GREAVES SUBDIVISION FILING NO. 1

A REPLAT OF LOT 13, WILDWOOD RANCH ESTATES FILING 7

EPC STORMWATER REVIEW COMMENTS
IN ORANGE BOXES WITH BLACK TEXT

## GREAVES SUBDIVISION FINAL PLAT

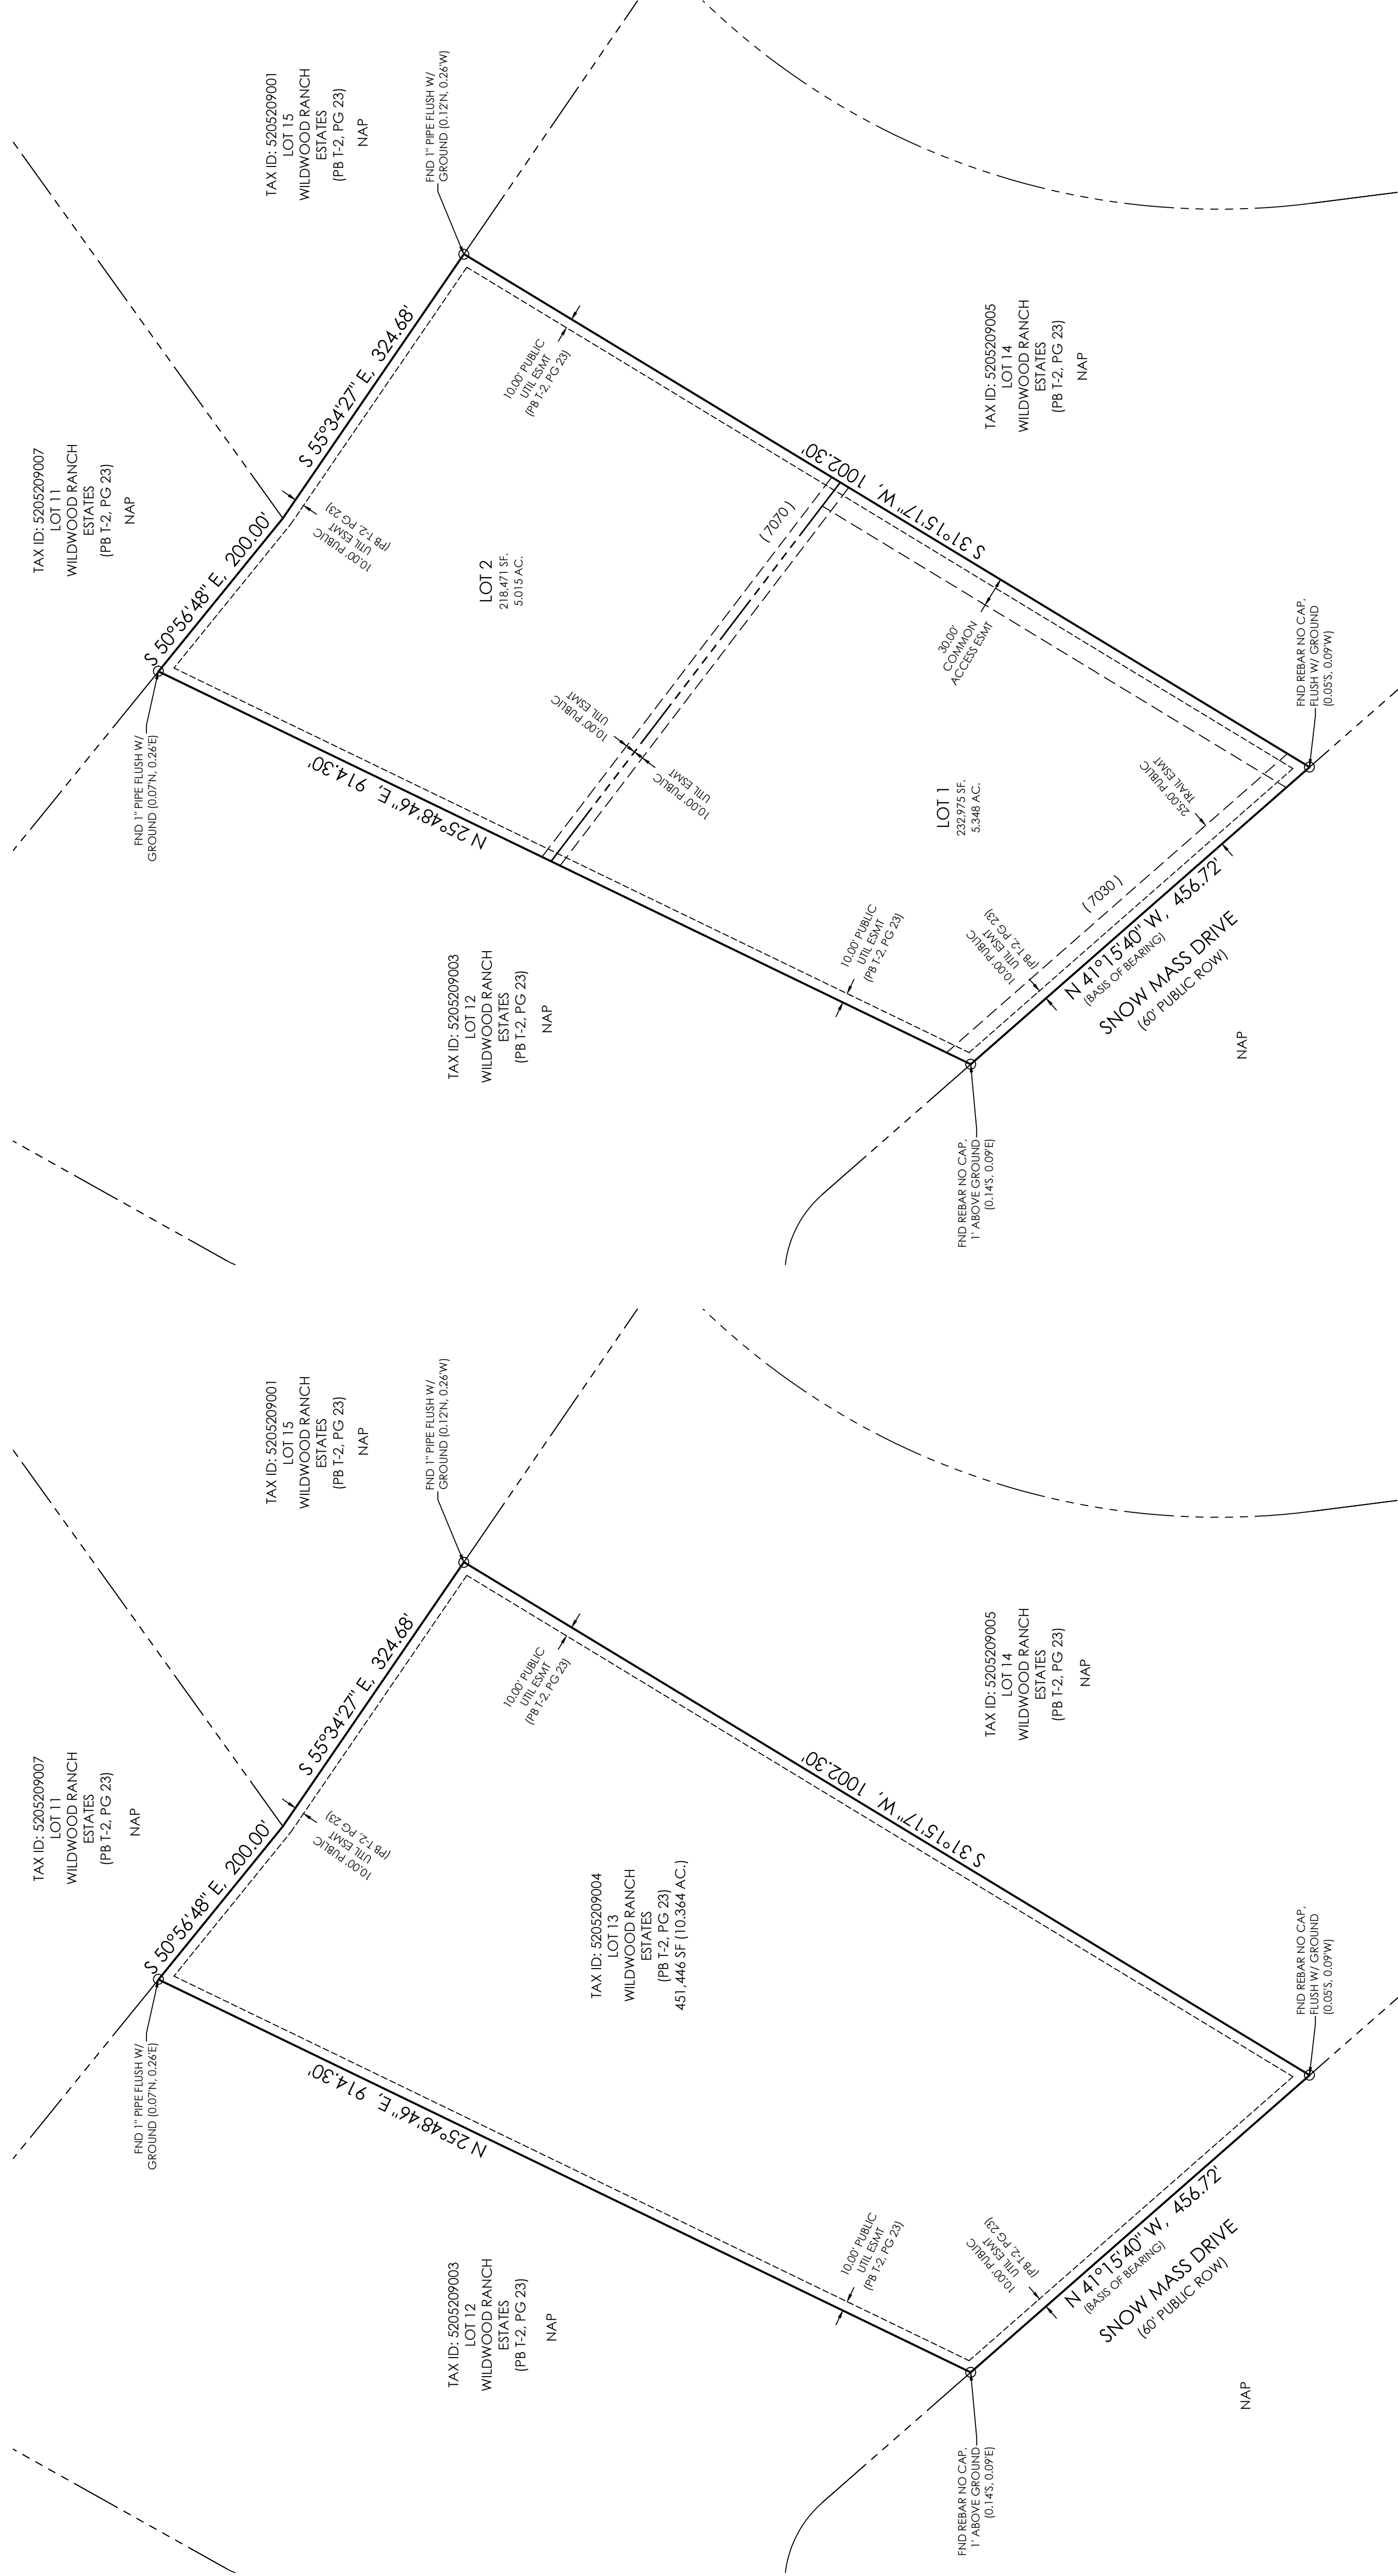
Please include statement below:
Absorption field must be located a minimum of 100 feet from any well, including those on adjacent properties.
Absorption fields must also be located a minimum of 50 feet from any drainages, floodplains, or ponded areas and 25 feet from dry gulches. Please add note in regard to On-site wastewater systems

Please include statement below:
Except as otherwise notes on the Preliminary Plan, individual lot purchasers are responsible for constructing driveways, including necessary drainage culverts per Land Development Code 6.3.3.C2 and 6.2.2.C.3. Due to their length some of the driveway must be approved by the Fire District

Please include statement below:
The individual lot purchaser(s) shall be responsible for final design, construction, and maintenance of private detention pond/water quality BMP(s) as described in the approved Preliminary/Final Drainage Report for this subdivision. Final design, construction drawings and drainage report updates for the detention pond/water quality BMP(s) shall be provided with Site Development Plan submittals. The detention pond/water quality BMP(s) shall be constructed and completed prior to the issuance of any building permits for the subject lots. The subdivision developer is responsible for providing financial assurances as indicated in the Subdivision Improvements Agreement and Estimate of Guaranteed Funds for all detention ponds/water quality BMPs. All detention ponds/water quality BMPs shall be constructed prior to the release of said financial assurances. Individual lot purchasers shall enter into a Private Detention Basin / Stormwater Quality BMP Maintenance Agreement and Easement ("Agreement") prior to the issuance of any building permits for the subject lots. In the case that the developer constructs the detention pond(s), the developer shall enter into an Agreement for each pond constructed.

Please include statement below:
Tract _____ shall be utilized as _____ (park, neighborhood park, school site, fire station, drainage tract, etc). Ownership and maintenance of Tract _____ shall be vested to (name the entity: El Paso County, Special District, Homeowners Association, etc.) (Where multiple tracts are included in a single PUD or plat, the use of a tract table is encouraged.)

On the submitted PBMP form, Exclusion E "Large Lot Single Family Sites" was selected to exclude the site from a PBMP. The qualifications for this exclusion is presented in the ECM section I.7.1.B.5:

Add a note to the plat acknowledging that per ECM Section I.7.1.B.5, the residential lots impervious area may not exceed 10 percent unless a study is prepared in compliance with the requirements laid out in the above ECM Section and the impervious area may not exceed 20 percent. This impervious area for each lot must include the proposed driveway.

Please include statement below:
Unless otherwise indicated, all side, front, and rear lot lines are hereby platted on either side with a 10 foot (use 5 feet for lots smaller than 2.5 acres) public utility and drainage easement unless otherwise indicated. All exterior subdivision boundaries are hereby platted with a 20 foot (use 7 feet for lots smaller than 2.5 acres) public utility and drainage easement. The sole responsibility for maintenance of these easements is hereby vested with the individual property owners.

Please include statement below:
The private roads as shown on this plat will not be maintained by El Paso County until and unless the streets are constructed in conformance with El Paso County standards in effect at the date of the request for dedication and maintenance.

Please include statement below:
Lot _____ (or Tract _____) (or entire property) of this property is subject to a Private Detention Basin/Stormwater Quality BMP Maintenance Agreement and Easement as recorded at Reception No. _____ of the records of El Paso County. The HOA (or Owner or District) is responsible for maintenance of the subject drainage facilities.
Watershed Dam Note (To be used when the subdivision affects or located in areas which are inundated by the high water line of a watershed dam, or downstream in the impacted area.)

Please edit.
